Wilby Manor Barns, Wooten Green, Wilby, Suffolk, IP21 5LB

Wilby Manor Barns have been granted planning and listed consent for conversion. Full planning and listed consent was granted under DC/21/04312 Planning and DC/21/04313 Listed Consent. The barns were in a state of partial collapse and at planning stage a structural engineer had confirmed safe access was not possible hence the conditions applied to the consents.

## Matters Arising from Heritage Visit During Construction

CLIENT Subgero Limited			
PROJECT Wilby Manor Wooten Green Wilby Suffolk IP21 5LB			
DRAWING Section B-B			
SCALE 1:20 @ A1	DATE March 2022	DRAWN BY IJT	CHECKED
DRAWING NUMBER WD05	JOB NUMBER 547	STATUS CONSTRUCTION	REV C

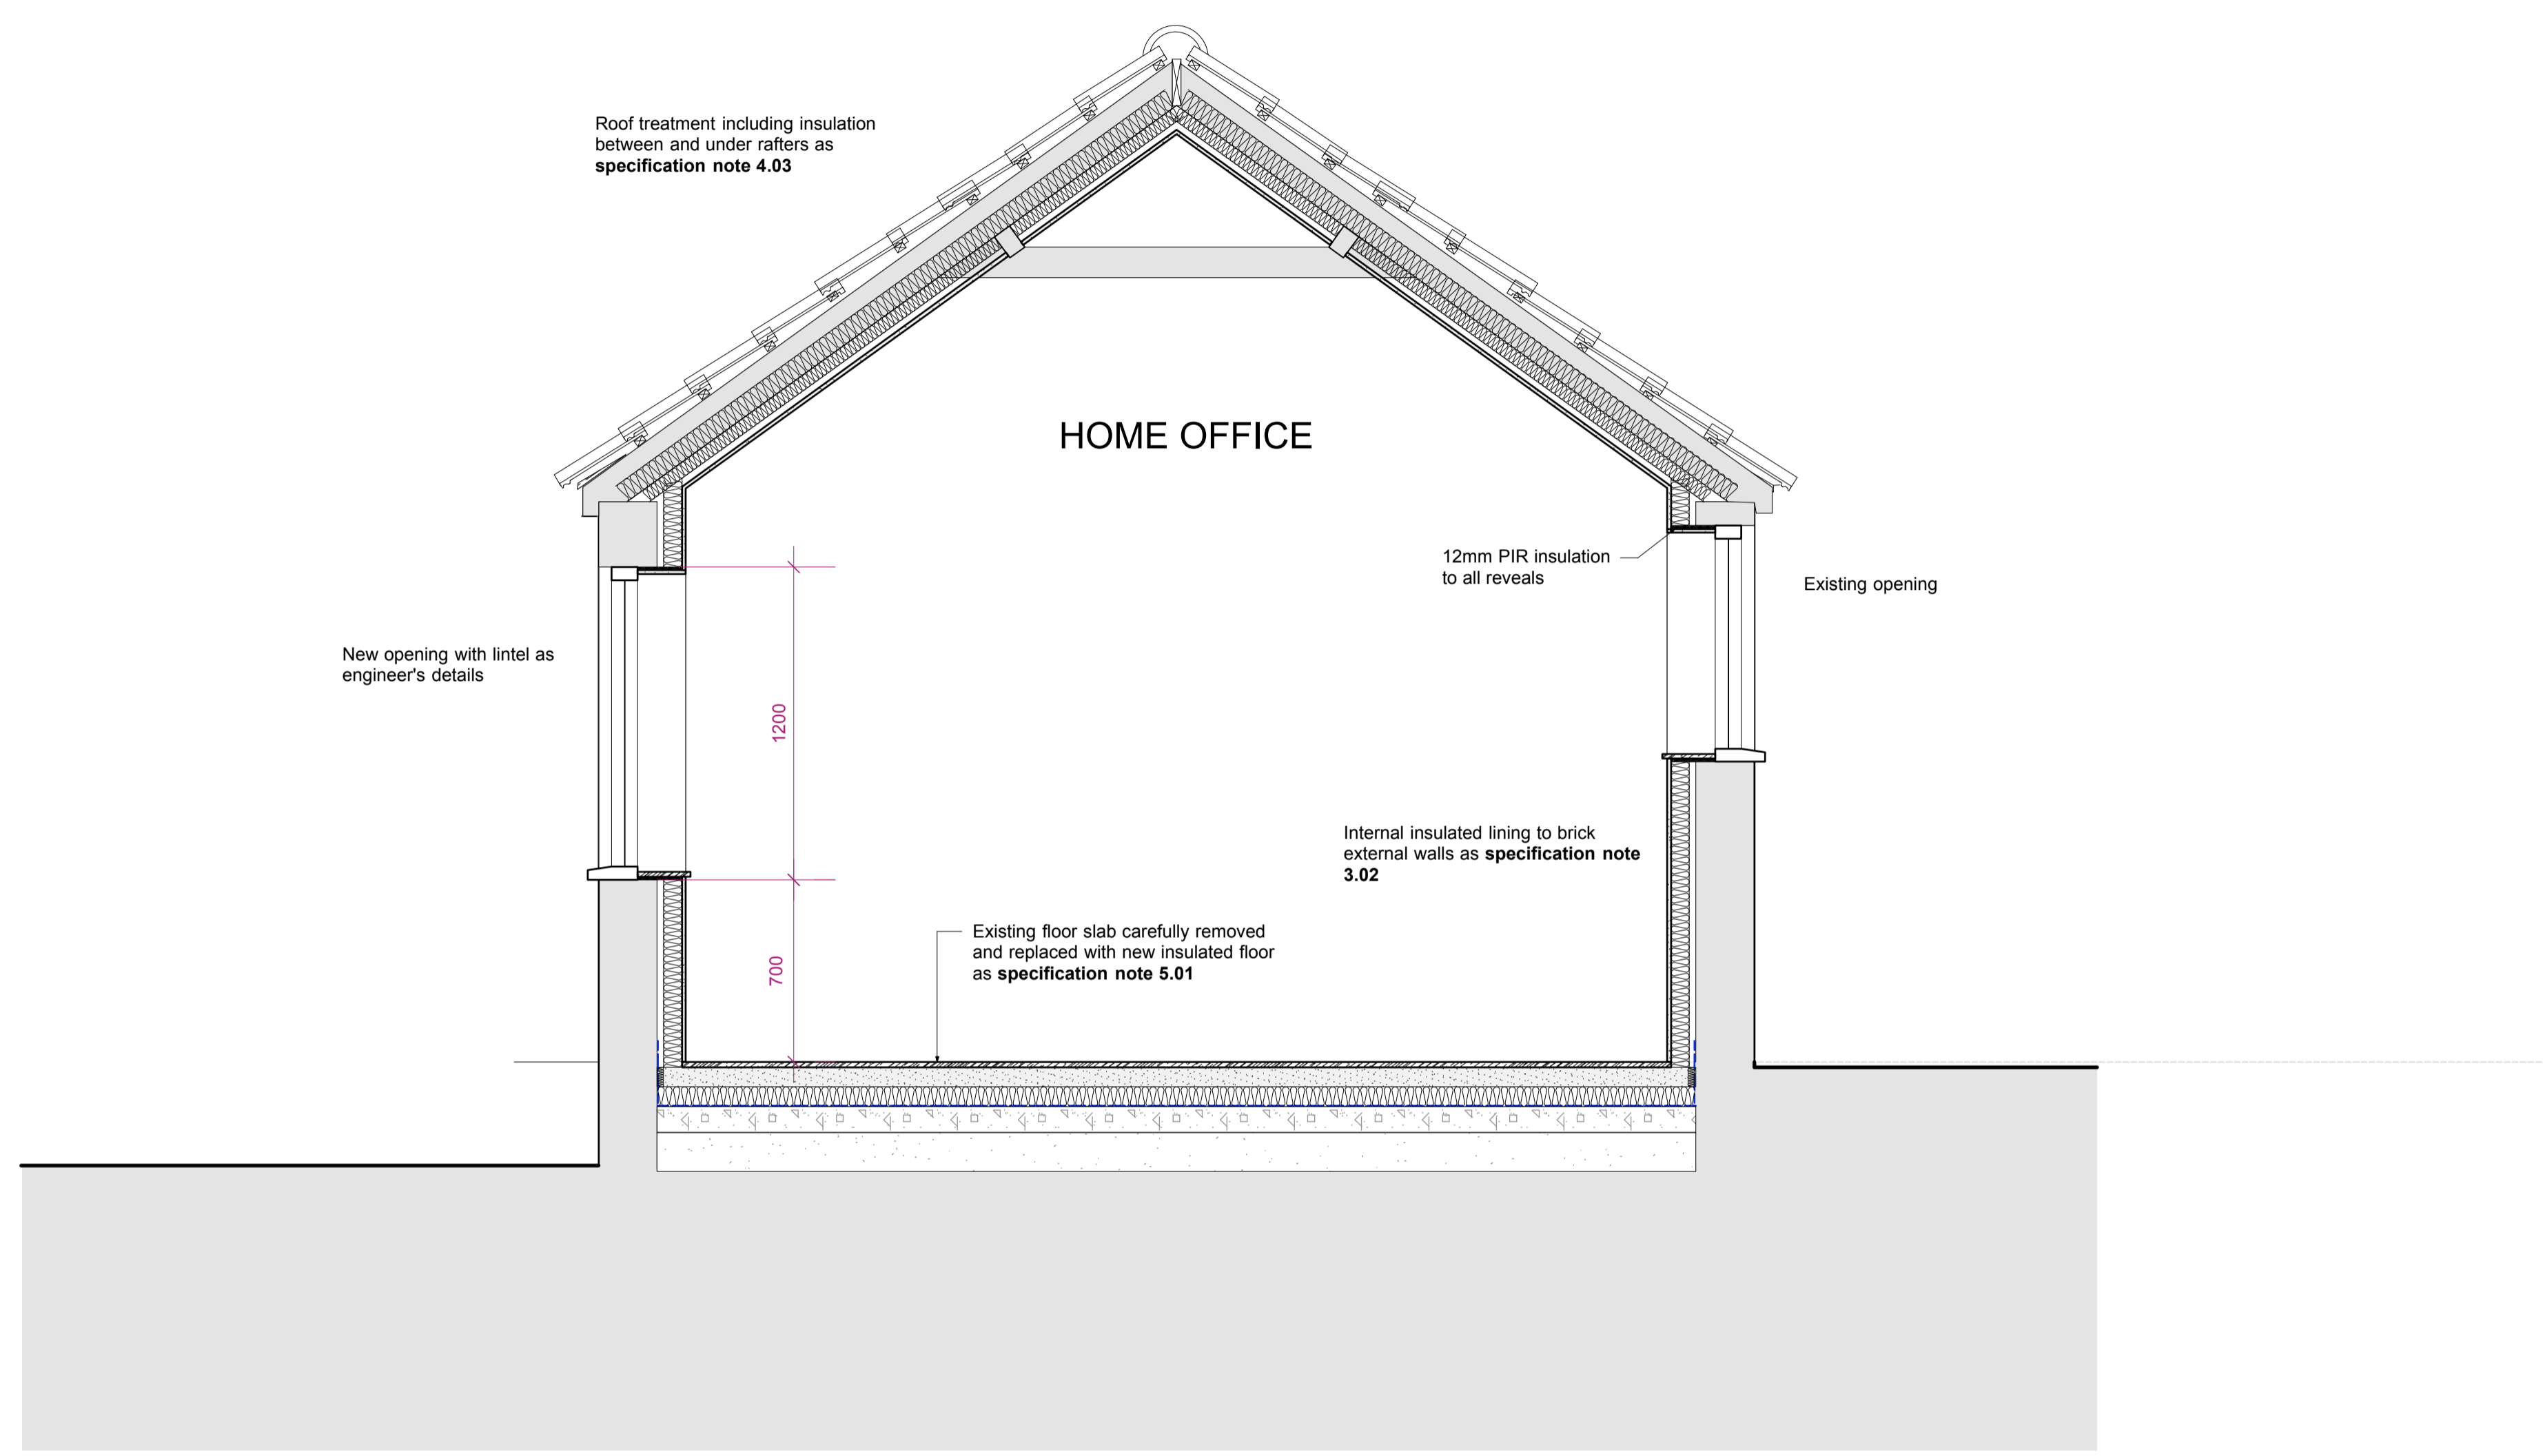
Condition 4 (Details of New Wall and Roof Build-Up) – This condition was applied as ‘notwithstanding,’ which is designed to mean that there is not yet any approval for any works listed in the condition, even if such works are shown on documents listed in the decision notice. Having reviewed my photographs from the site visit, it also appears that the roof insulation in the single storey range does not match the section drawing included in the original application anyway, as the Celotex? insulation has been installed between the rafters in this range. Again, I would therefore request that to start with a Discharge of Conditions Application to either retain or amend these works, with clear and convincing justification and measured section drawings, as per the condition wording, is submitted ASAP.

Attached drawing WD05C also shows a minimal amount of Celotex used in the single storey Victorian wing roof (modern roof rafters). This is ventilated over to ensure there is no condensation risk and due to the use of the Celotex material and ventilation no internal or external change in appearance has occurred through the conversion.
